CITY OF ALBUQUERQUE

Re: Gibson Gas Station
Northeast corner of 98th St and Gibson Blvd.
Traffic Impact Study-draft, HT#M09D034
Report dated October 2022
Engineer's Stamp -----
Via email jkruse@lee-eng.com

The subject Draft Site Traffic Analysis received on October 25, 2022, has been reviewed by the City of Albuquerque Planning Development Transportation Section. The City has the following comments:

PROPOSED TRAFFIC CIRCULATION PLAN

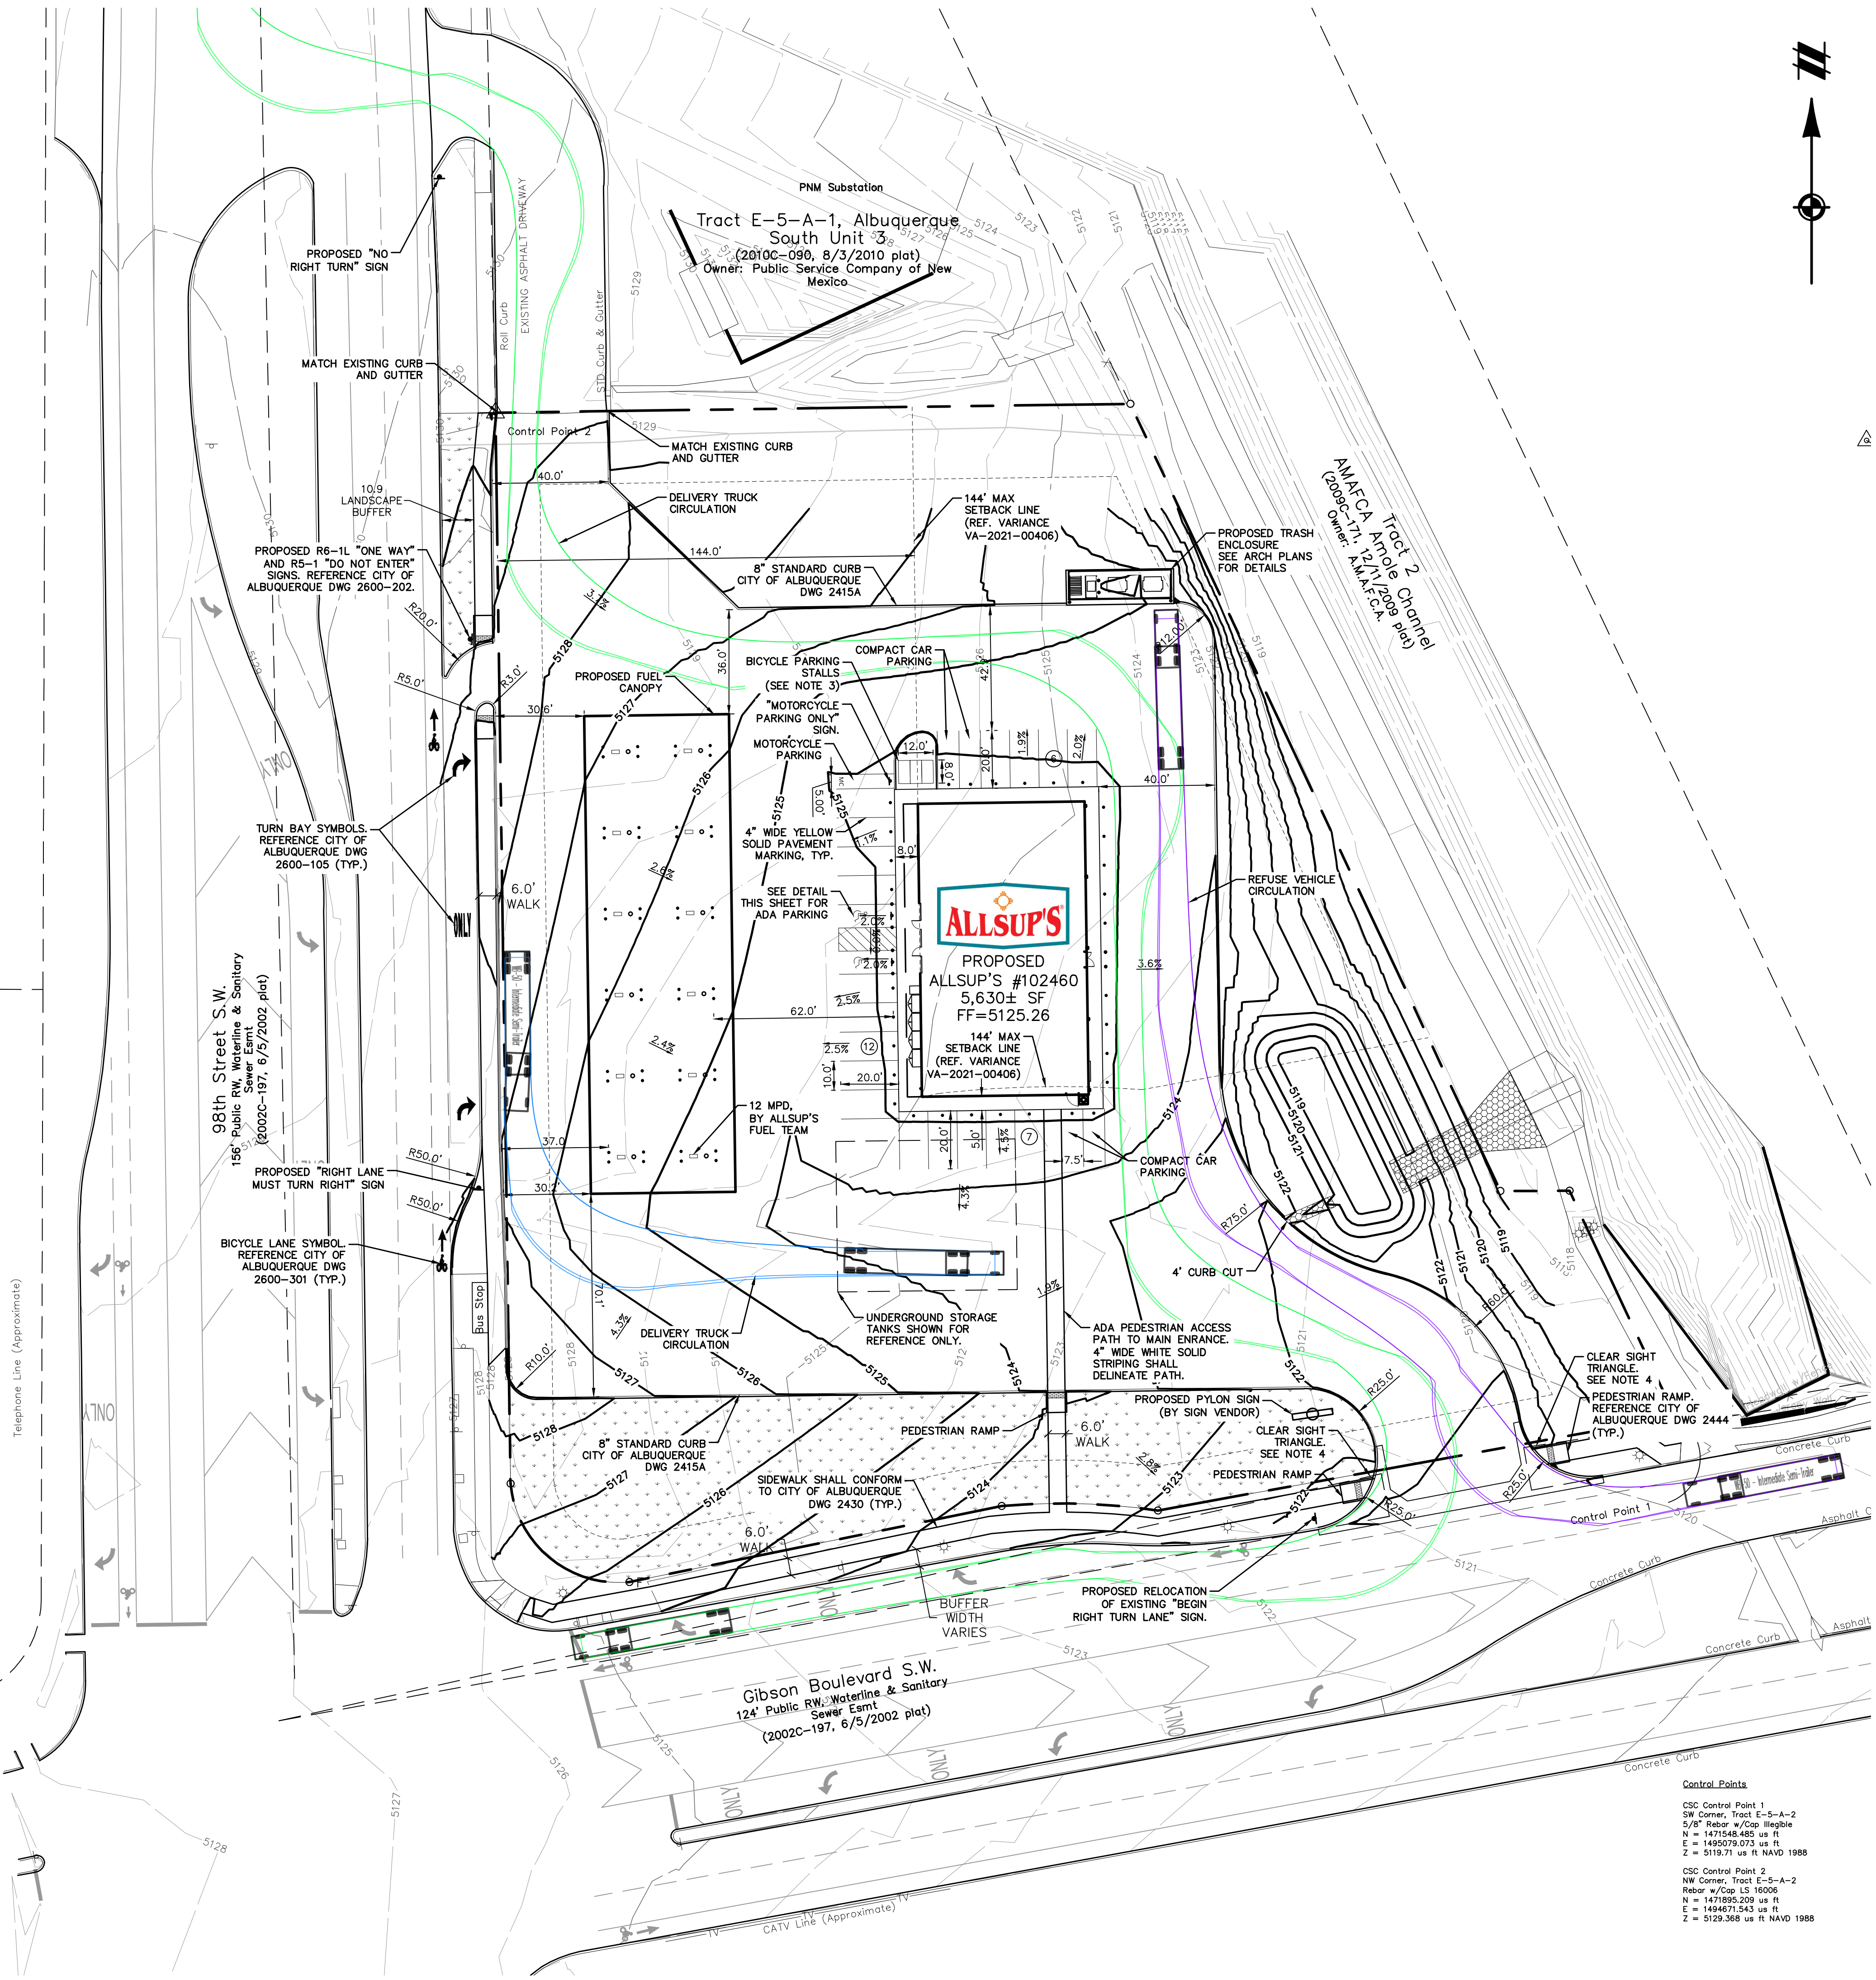
- Locate Driveway B as far east as practicable. This will improve the access to the westbound left-turn at 98th St and provide space for future lengthening of the right-turn lane.

- Relocate Driveway A to the north limits of the development.
 - Add a right-turn lane, the length may be less than the DPM requirement. The City may accept a reduced length of the turn lane. Provide a short discussion on the effectiveness of the modified turn lane.

- The transit stop should remain as is. The northbound right-turn lane can begin immediately north of the transit shelter.
 - The access to the PNM facility should remain. Add a notification sign that this driveway is for PNM access only/dead end or what you feel is needed to discourage erroneous use of this driveway. The developer should coordinate with PNM concerning this driveway.
